RESPONSE TO SUBMISSIONS REPORT

MAJOR PROJECT APPLICATION NO. 08_0194

**KINGS FOREST STAGE 1
SUBDIVISION AND BULK EARTHWORKS**

MAY 2012

Bulk Earthworks Sequencing Diagram
Dwg No. 12301-All-041 to 50(A)
Prepared by Mortons-Urban Solutions

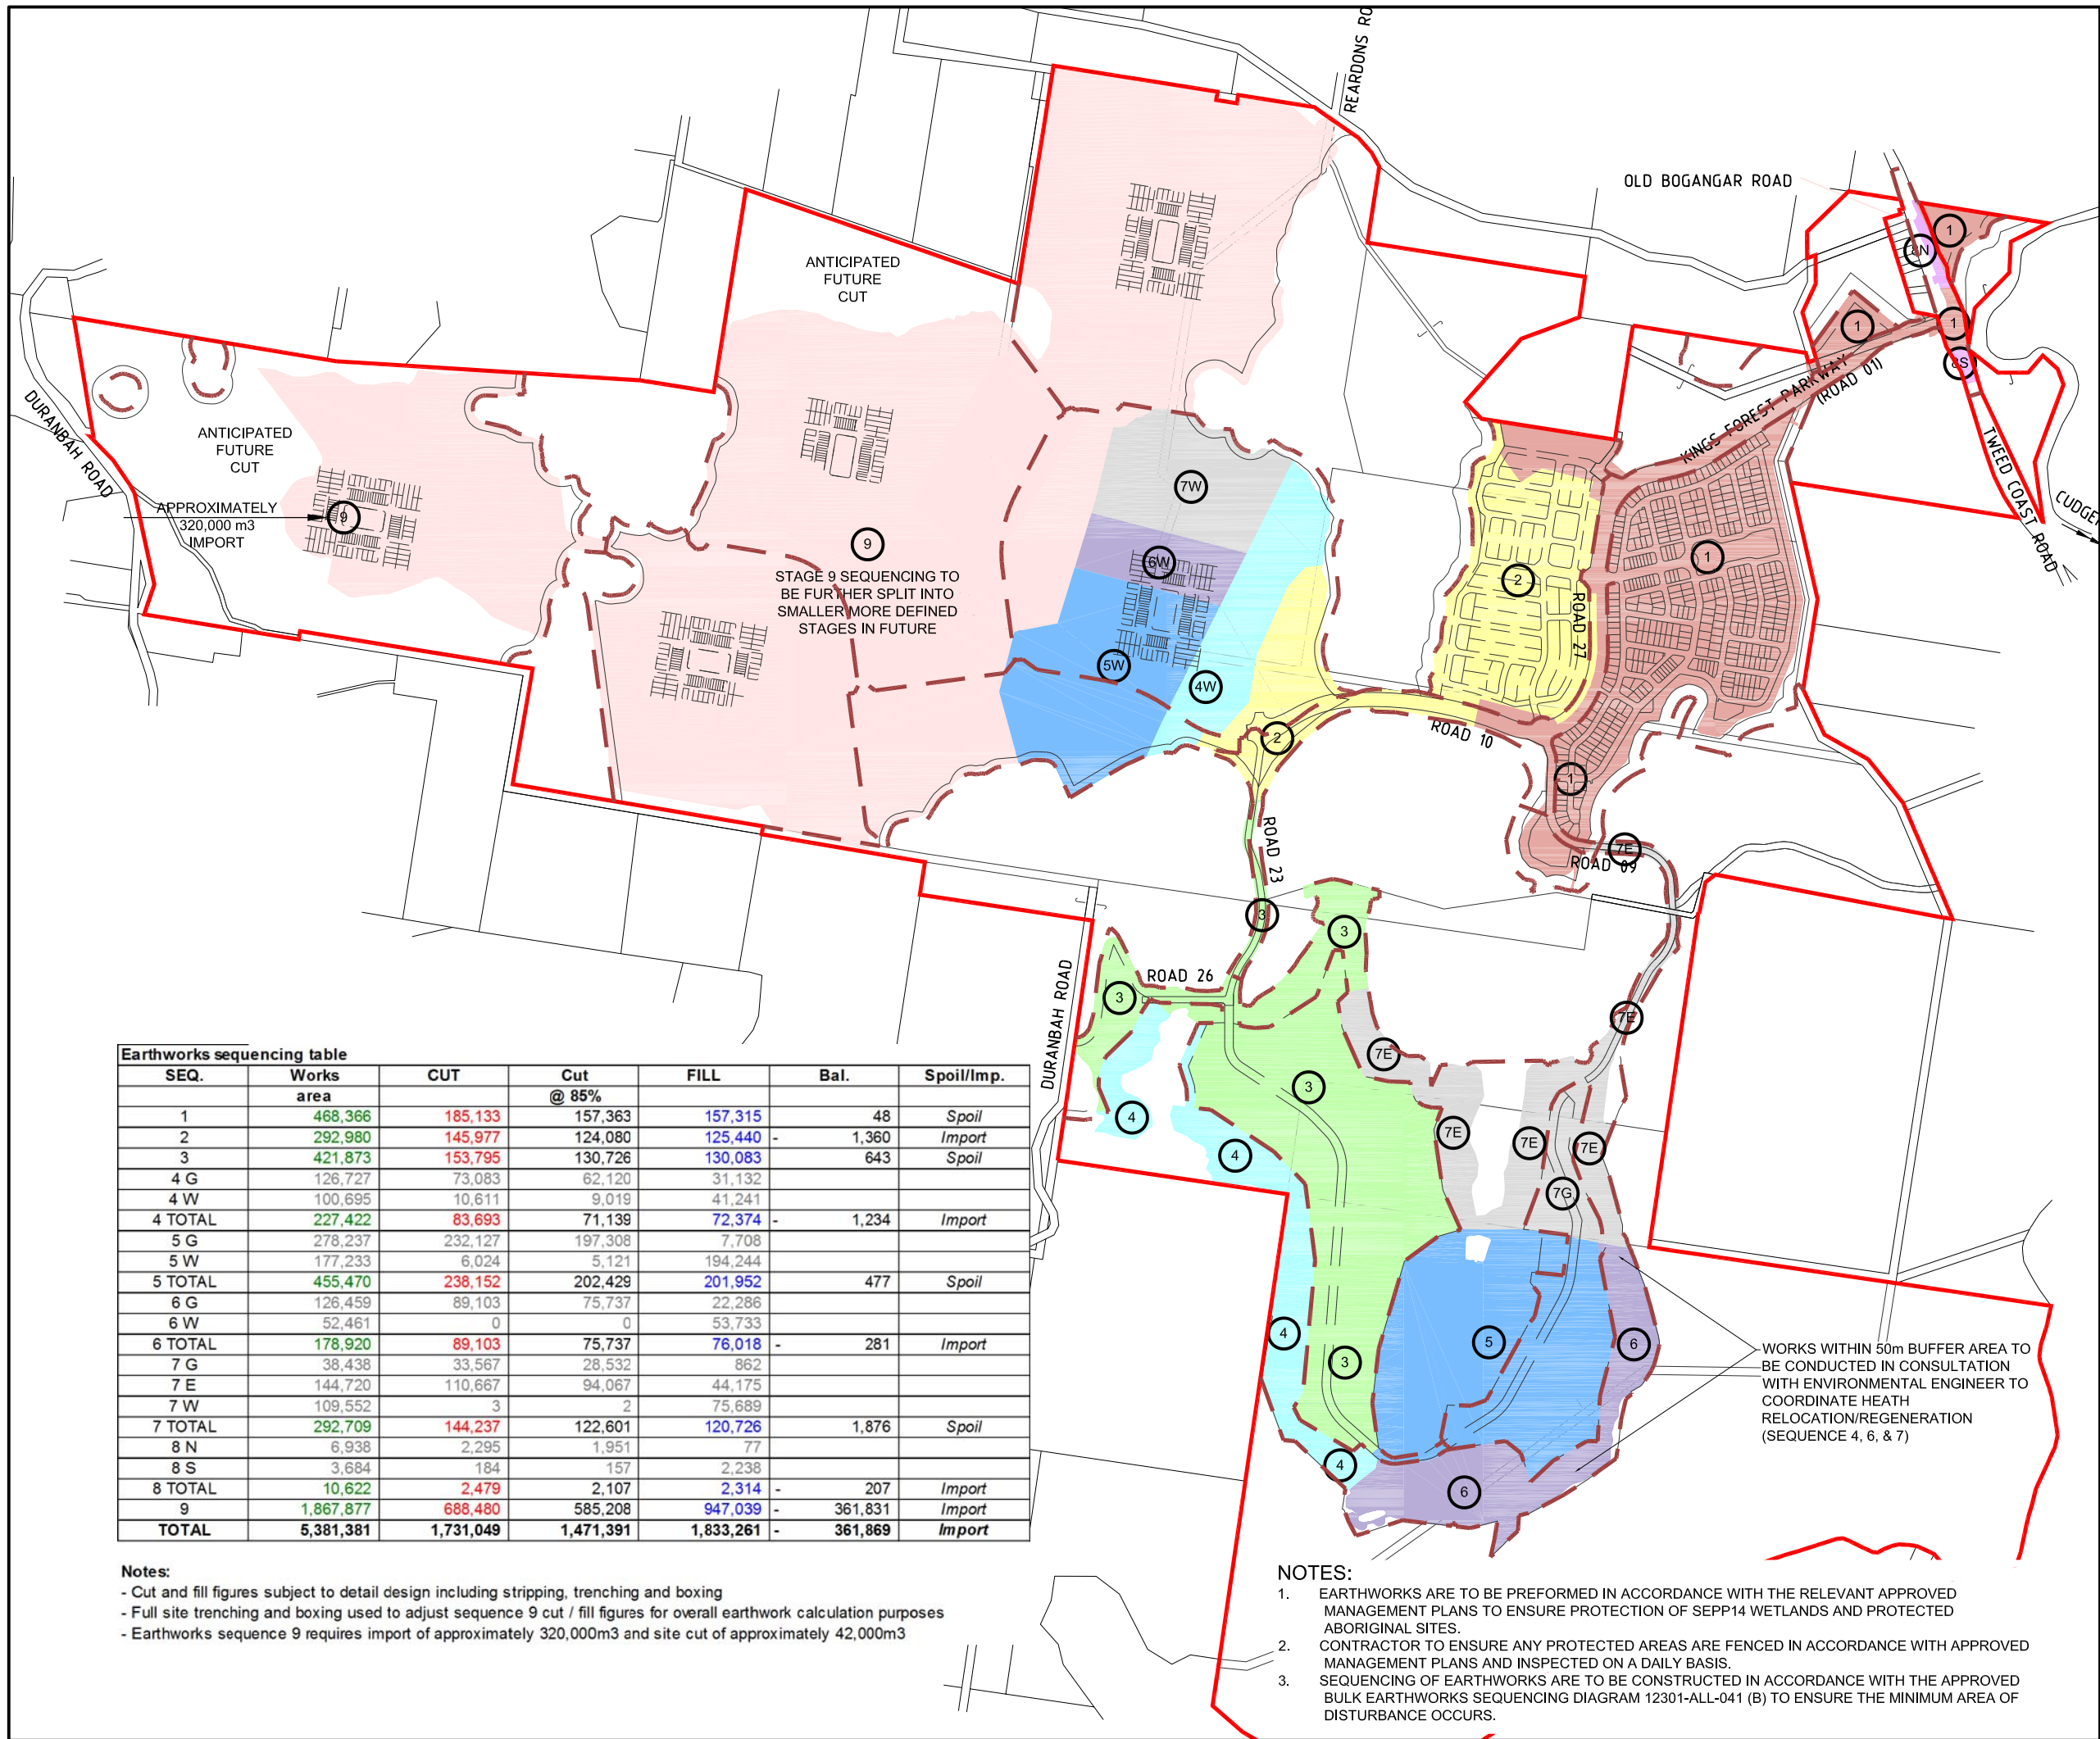
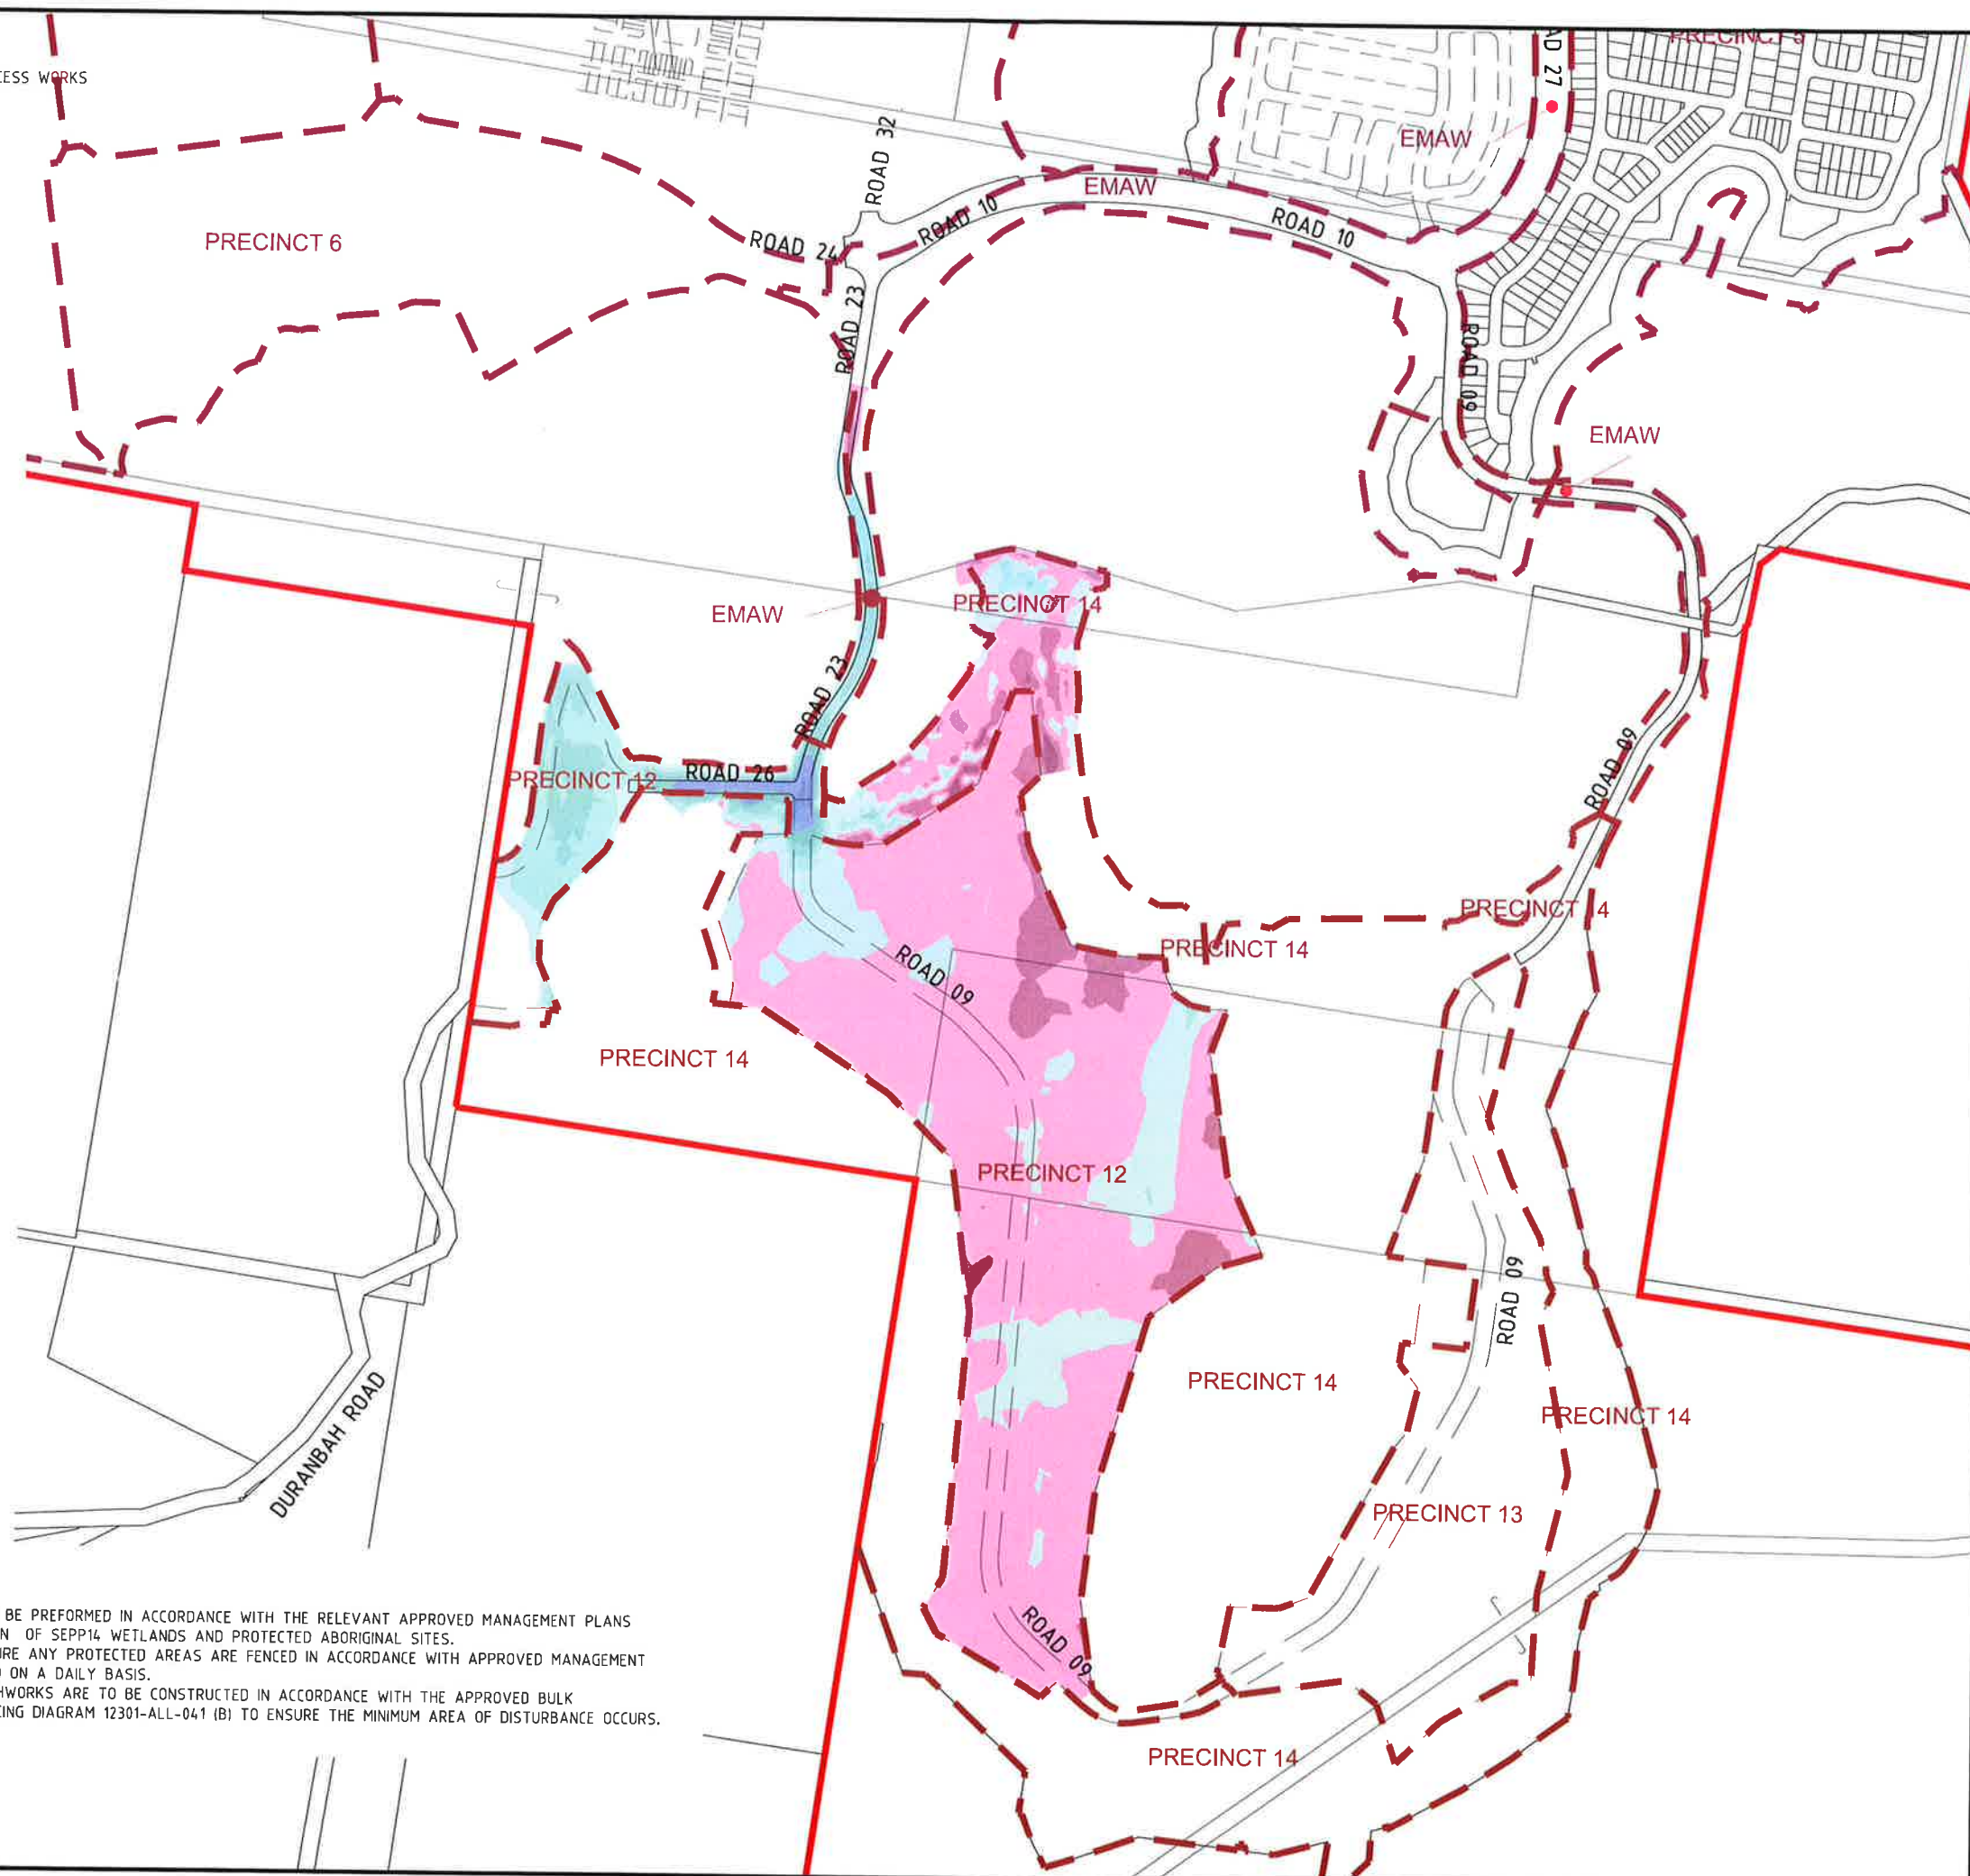
64		The department requires further detailed plans showing the sequence of earthworks and maximum exposed areas	Detailed plans will be provided with the PPR.
65		Plans submitted for earthworks in Precinct 4 are not sufficiently detailed for Project level approval	Clarify with DOPI what further detail is required. Detail will accompany the Construction Certificate Application.
66		Further details are required of the proposed recipient location of fill from Precinct 5 (and Precinct 4 if further details are provided) to enable movement of fill from Precinct 5	See response to Item 64 .
67		Further discussion is required on how the bulk earthworks across the rest of the site is intended to be undertaken	See response to Item 64 .
68		AS 3798-2007 Guidelines for earthworks for commercial and residential development should be referenced	Plans and reports will be amended to refer to AS3798-2007.
69			
70		00. DoP / Eco Logical Australia Pty Ltd (ELA)
